Application for a non-material amendment following a grant of planning permission.
 Town and Country Planning Act 1990

HOUSEHOLDER PLANNING APPLICATION - DEMOLITION OF EXISTING 2 STOREY REAR EXTENSION AND SINGLE STOREY CONSERVATORY TO BE REPLACED WITH A NEW 2 STOREY REAR EXTENSION AND RAISING THE RIDGE HEIGHT IN EXISTING DWELLING (AMENDED SCHEME TO DC/19/04442)

DC/20/02070

MODIFICATION TO THE EXISTING PORCH AND GARAGE DESIGN

**Drawing Title:**  
RD002-001  
PLANNING DRAWINGS

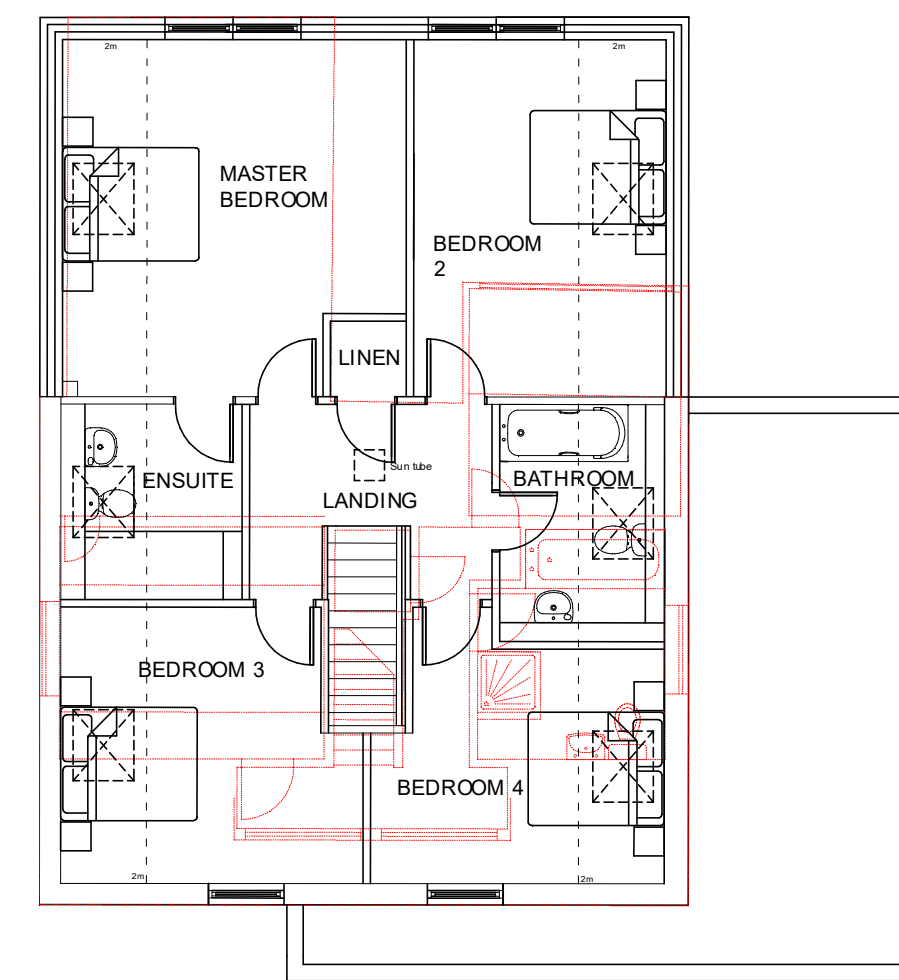
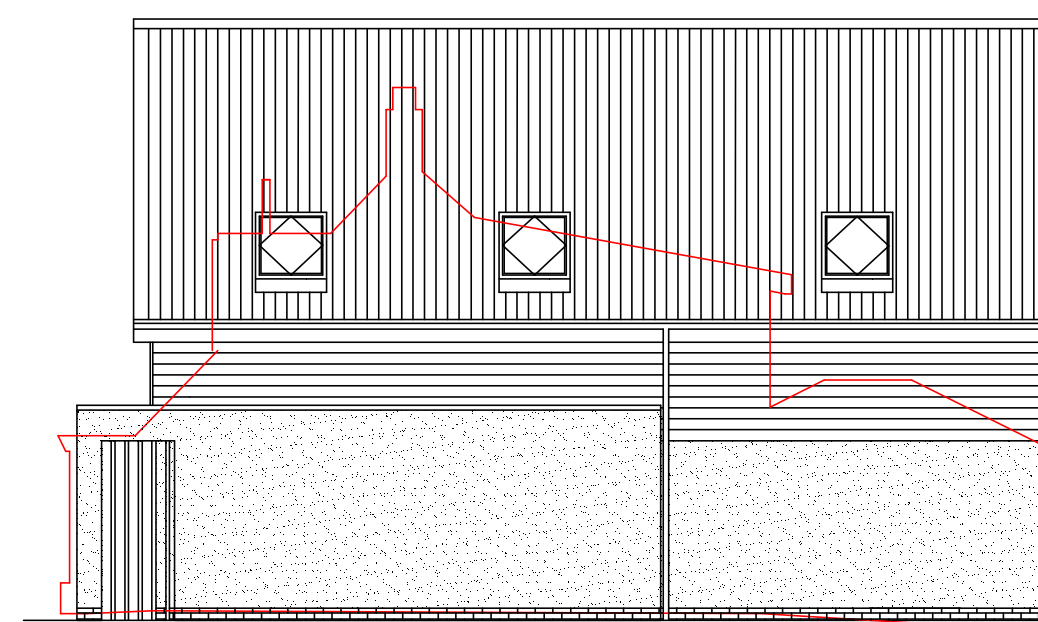
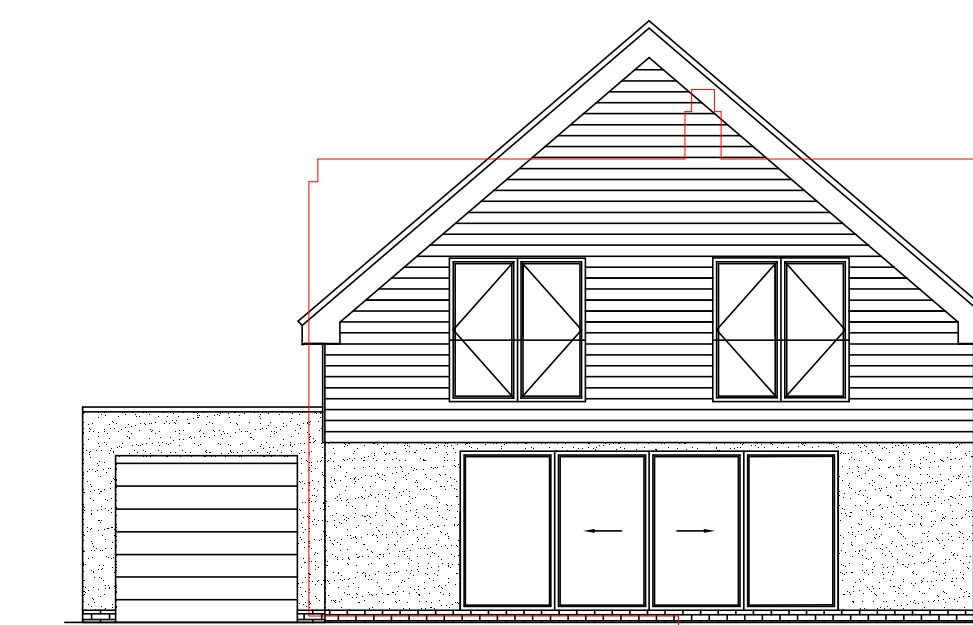
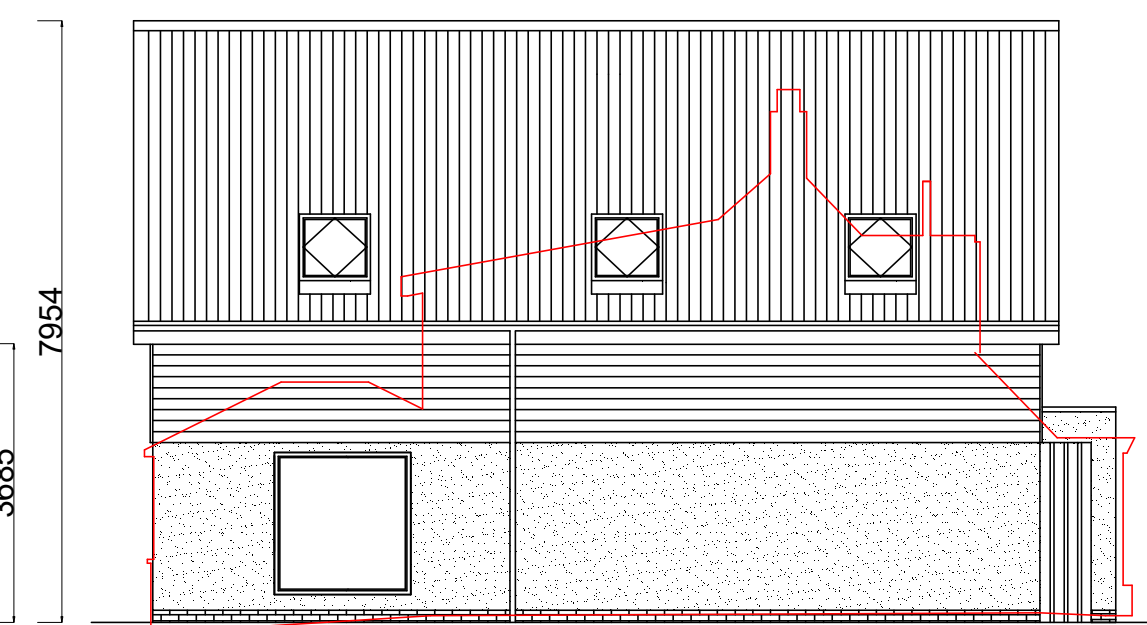
TO TIE THE GARAGE AND PORCH TOGETHER TO MAKE IT LOOK MORE AESTHETICALLY PLEASING, IT WILL ALSO MAKE THEM LOOK INTEGRAL TO THE ORIGINAL HOUSE DESIGN.

RD002 - 001 REV 0.1 DATED: 02/11/22
